Wilpshire Parish Council

Planning Application 3/2016/1046 Enlargement of existing bay to the front elevation at 46 Knowsley Road, Wilpshire

**P1 Proposed Front (west) Elevation**  
1 : 100 N160

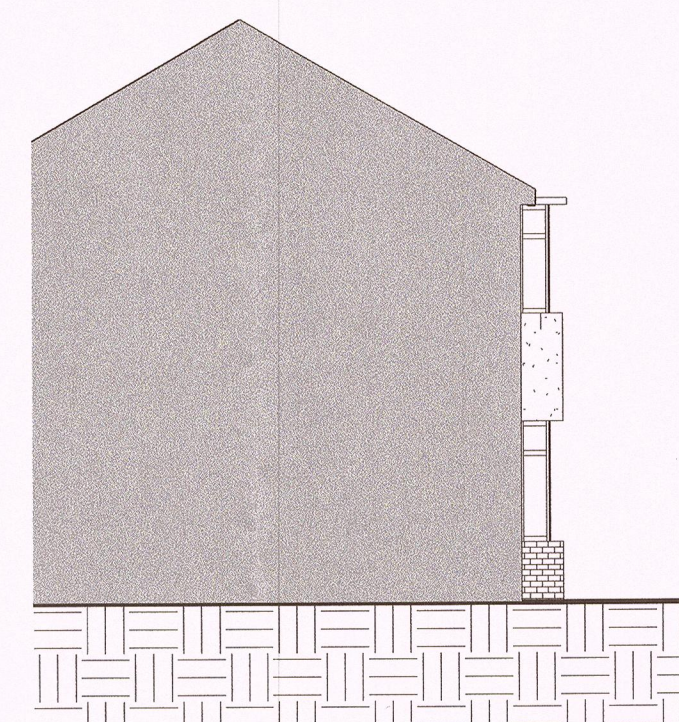
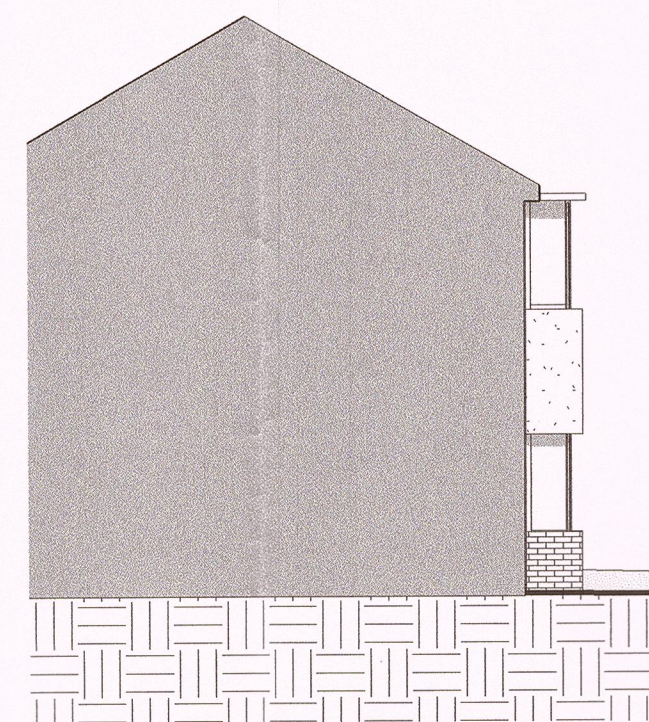
The development would have an adverse affect on the street scene. The house is a semi detached and the enlargement of the existing bay to the front would lose the symmetry of the pair of properties.
